From: David Innes
Sent: 03 October 2017 13:27
To: Planning.Responses
Subject: FW: Planning Application A/11/17/OUT

Land South of A259 New Road and East of Brook Lane, Angmering, West Sussex – Planning Application A/11/17/OUT

**Land South of A259 New Road and East of Brook Lane, Angmering, West Sussex –
Planning Application A/11/17/OUT**

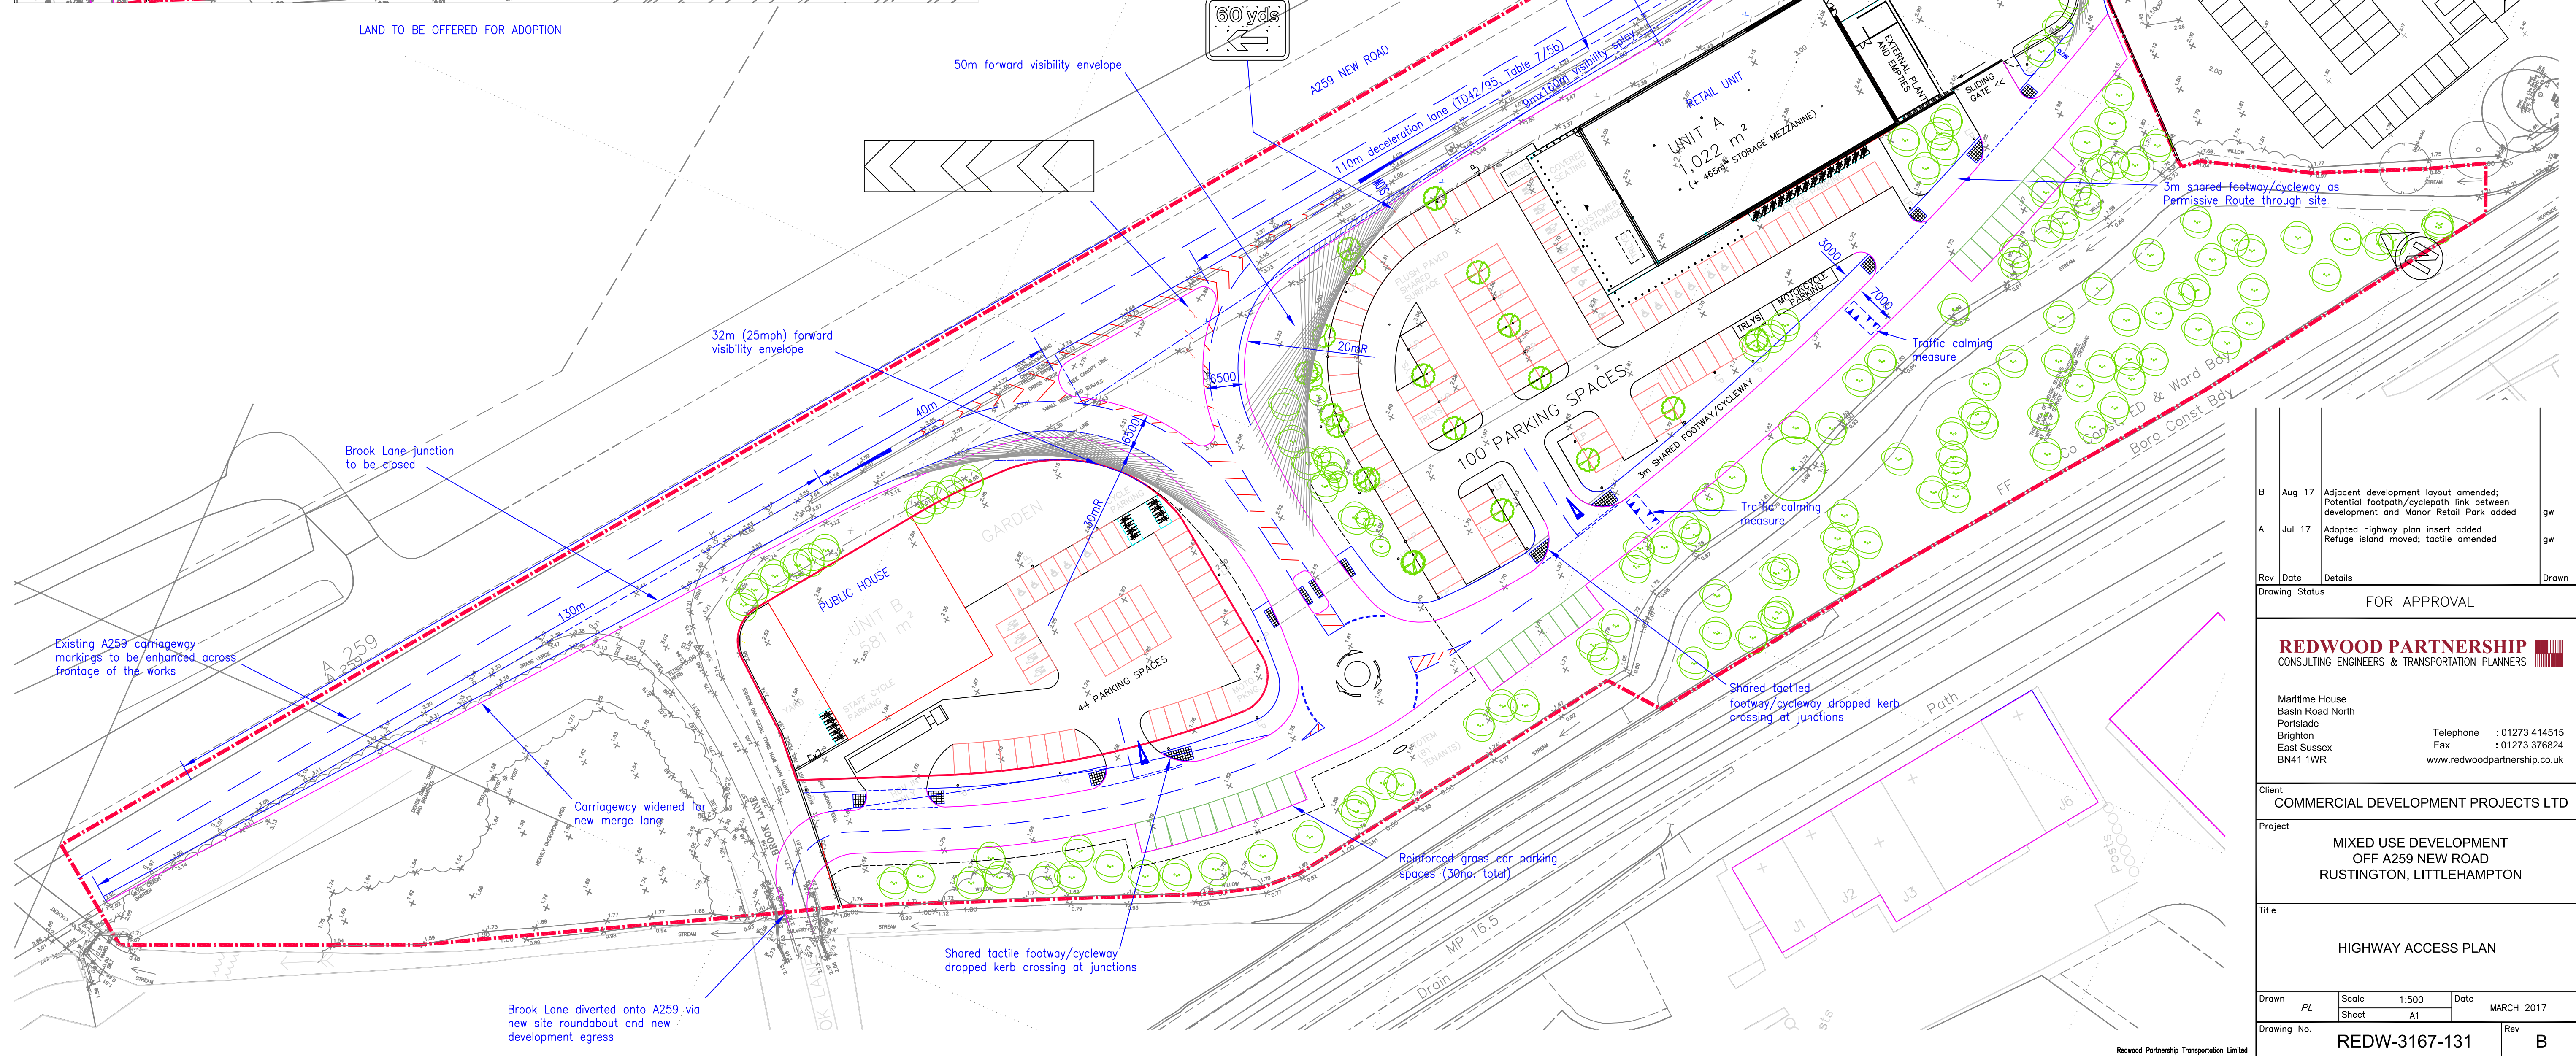
In respect of the access arrangements, these have been reviewed on the basis that Brook Lane is closed as shown on plan REDW-3167-131 Rev B. The condition suggested by the LHA requires that the access be implemented in accordance with the agreed plan. The LHA are of the view that the condition would require the closure of the road, given that this is shown on the plan. However, it is recognised that Brook Lane sits outside of the redline boundary, and therefore may not be sufficiently covered by the suggested condition should the need for enforcement occur. The LHA are satisfied to defer to the LPA's judgement as to whether the closure of Brook Lane should be specifically referred to in any condition attached should consent be granted.

The proposed access arrangements are shown on Redwood Partnership's updated drawing number REDW-3167-131 Rev B. The Redwood Partnership's letter states that it would be necessary to close Brook Lane in order to implement this access. I therefore request, on behalf of our client Store Property Investments Ltd, should consent be granted that this requirement is conditioned. In addition, in the interests of highway safety, I request that no work should be allowed to commence on the development until it is known that the existing access to the A259 can be stopped up. The following condition is suggested:

The Made Order to secure the stopping up Brook Lane's existing access to the A259 should be obtained in advance of the commencement of the development. Brook Lane's access to the A259 should be stopped-up when the new access, as shown on Drawing REDW-3167-131 Rev B, is brought into use.

is contorted and narrows severely where it joins Brook Lane. Diverting Brook Lane, as proposed, would not provide a safe and suitable access.

The revised Redwood Partnership's drawing, REDW-3167-131 Rev B, confirms that the proposed layout would permanently prevent vehicular linkage between the application site and Manor Retail Park. As set out in my letter of 2nd August 2017, this is contrary to the NPPF. Our client has already confirmed, in their email dated 13th July, that the application site has full legal rights to access through Manor Retail Park.
